Application by Fosse Green Energy Ltd for an order granting development consent for the
Fosse Green Energy solar farm

**Deadline 4 –
Comments on Submissions and
Information from Other Parties at
Deadline 3**

NKDC reference: 23/0325/NSIP

Planning Inspectorate reference: EN010154

Drawing file: published-documents / EN010154-000388-6.2 Fig 3-3 Permissive Paths.pdf

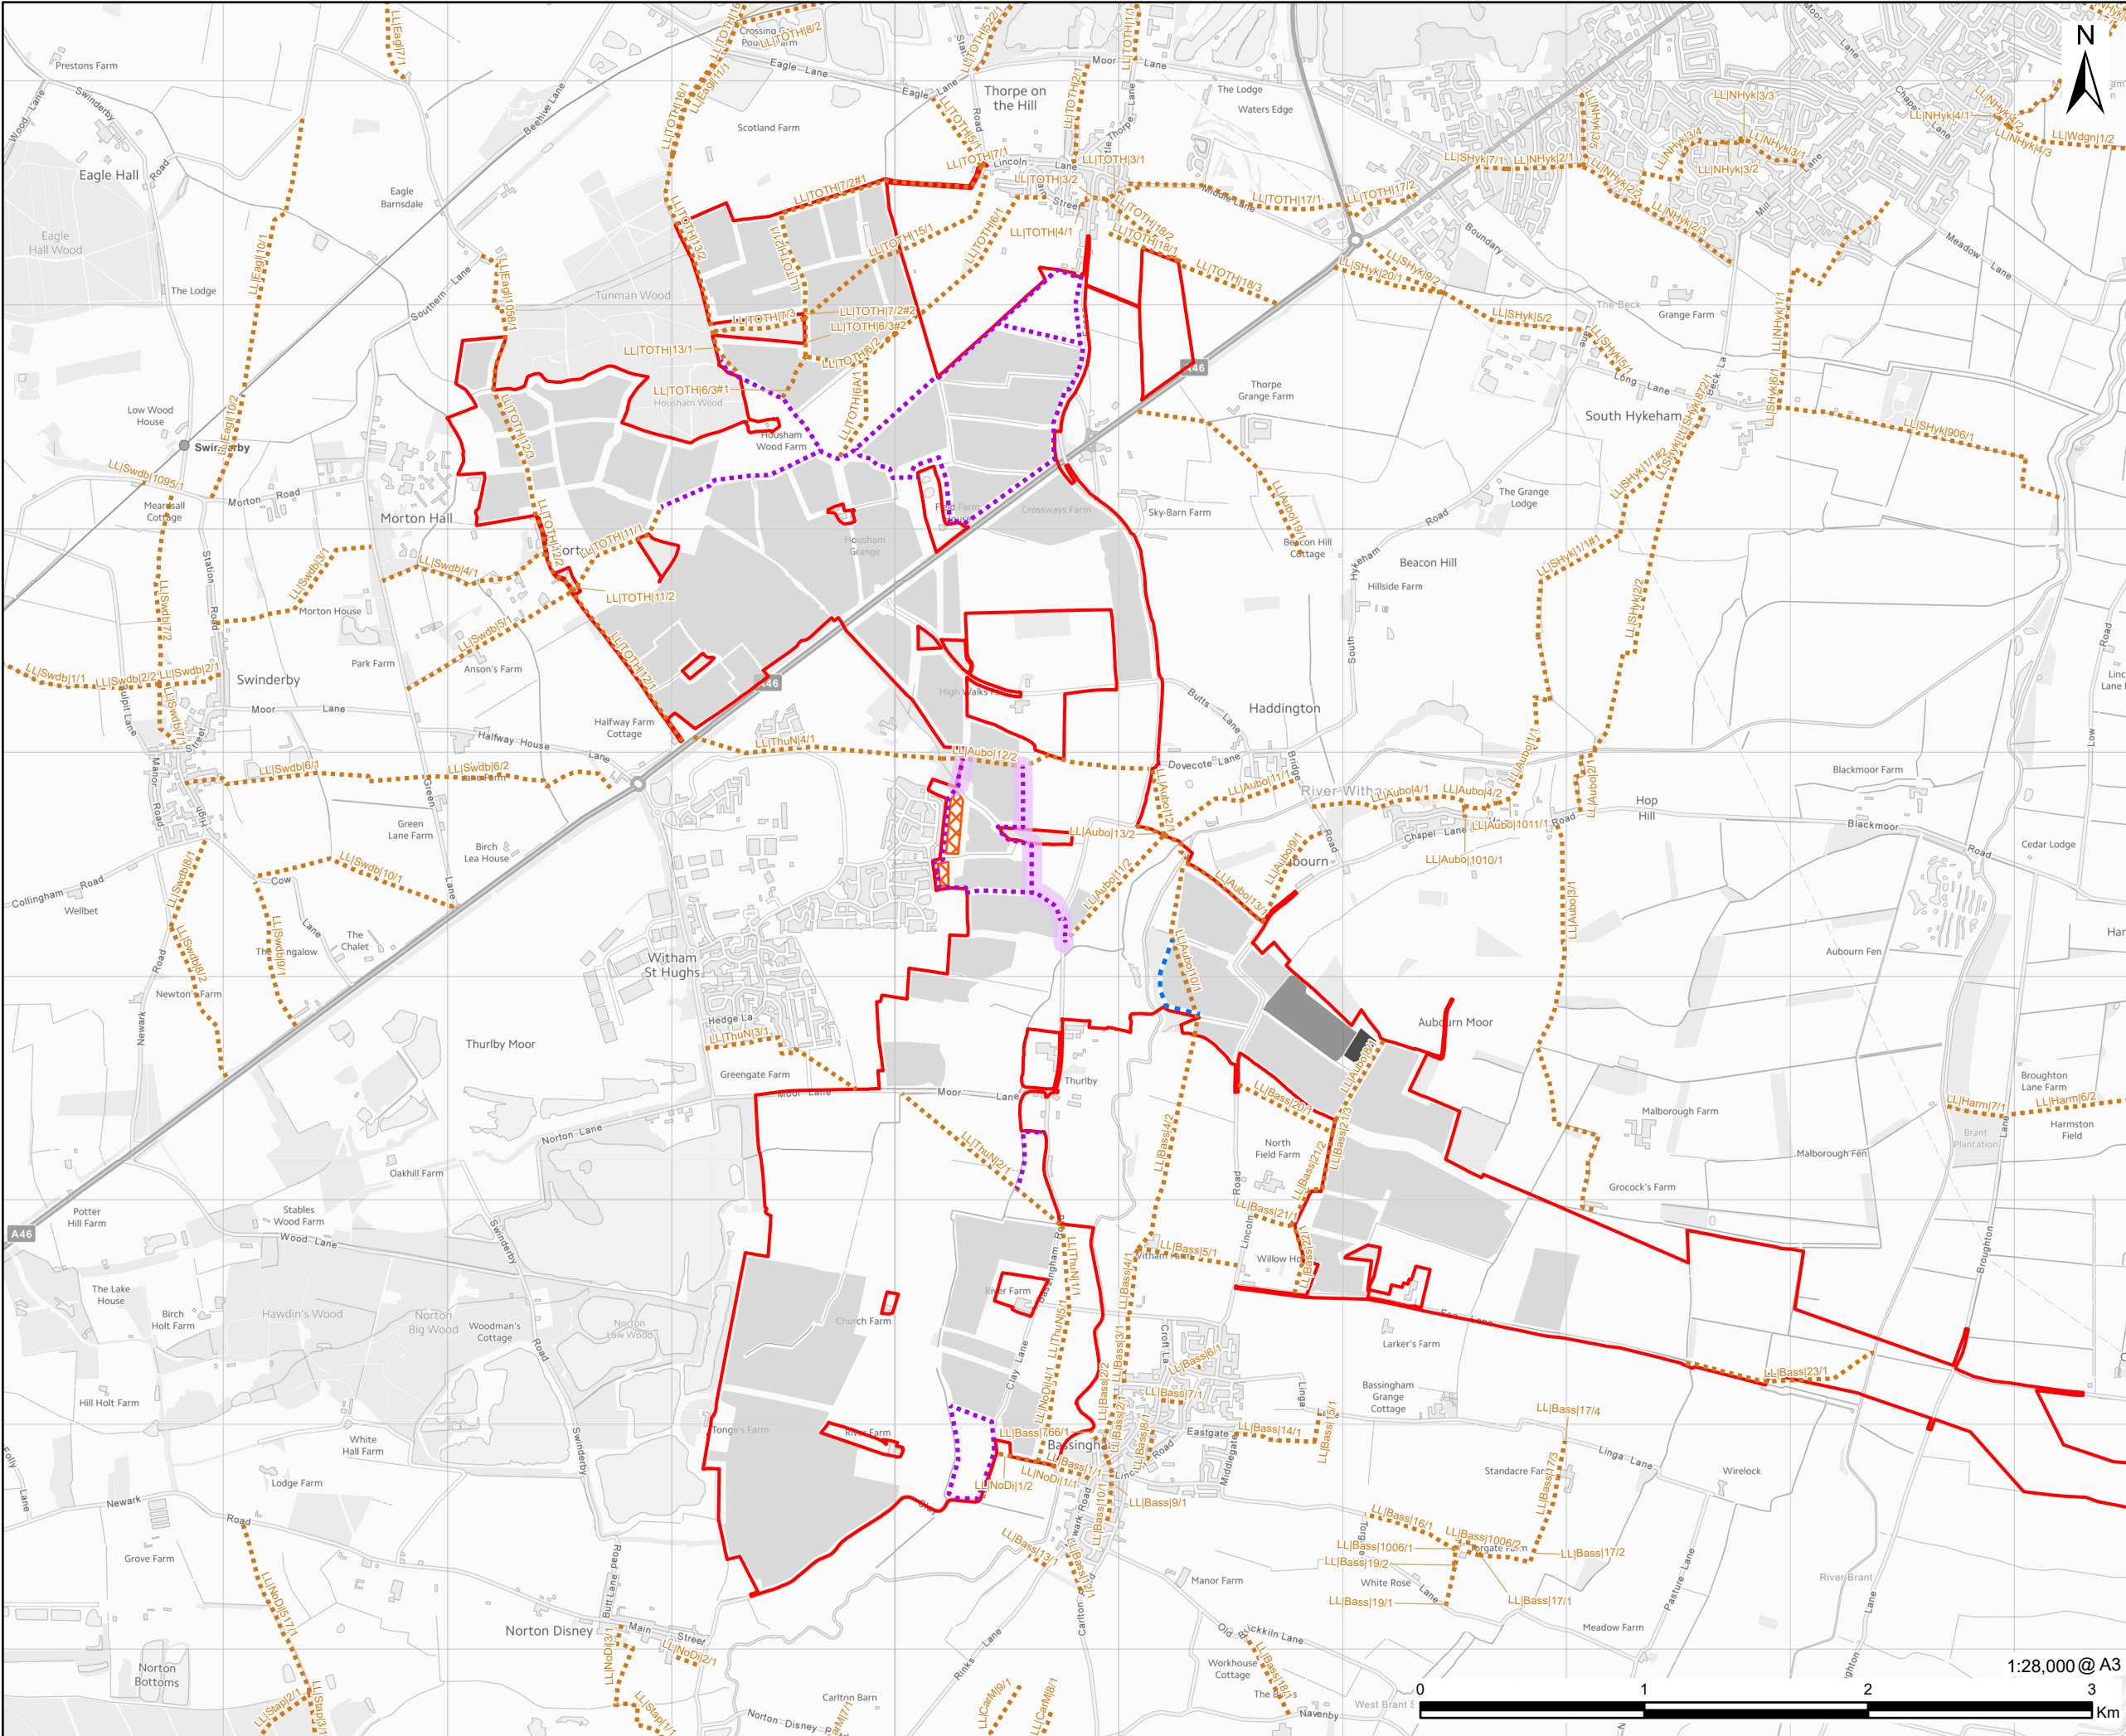
- 2.22 In **paragraph 6.1.1** of the FLEMP the Applicant refers to Figure 3-3 Proposed Permissive Path Plan of the ES (AS024). Figure 3-3 has been referred to in numerous submissions by the Applicant and the Council has repeatedly drawn attention to the inaccuracies. The Council is aware that the Applicant intends to submit a revised version of Figure 3-3 in the future. However, the Council considers that it should not avoid its obligations to correct previous statements and establish the baseline, existing situation on which its assessment of effects has been based – for instance in ES Chapter 12 where at paragraph 12.5.34 it states that there are seven permissive paths given the identifiers 15BCDE, 15BCD1, 17E42A, 15BCD0, 15BCCF, 15BC81 and 15BCC0. Despite requests, the Applicant has never revealed what paths those identifiers relate to.

- 2.55 Disappointingly, the Applicant continues to state that Figure 3-3 (AS-024) illustrates the retained and proposed permissive paths known by the Applicant. NKDC made oral submissions at Issue Specific Hearing 3 stating clearly that this figure did not show all existing permissive paths within the Order Limits. Subsequent to that hearing, NKDC met with the Applicant and showed a plan identifying a number of sections of existing permissive path which were not shown on Figure 3-3; this plan was discussed. On 17 March 2026 – in advance of Deadline 3 - NKDC submitted its Response to the Examining Authority's 2nd Written Question TT-2-03 which included lengthy material illustrating that the Applicant had failed to identify all existing permissive paths within the Order Limits, including a plan. That submission was provided to the Applicant the same day (17th March) so that the Applicant had it available when itself responding to question TT.2.04.
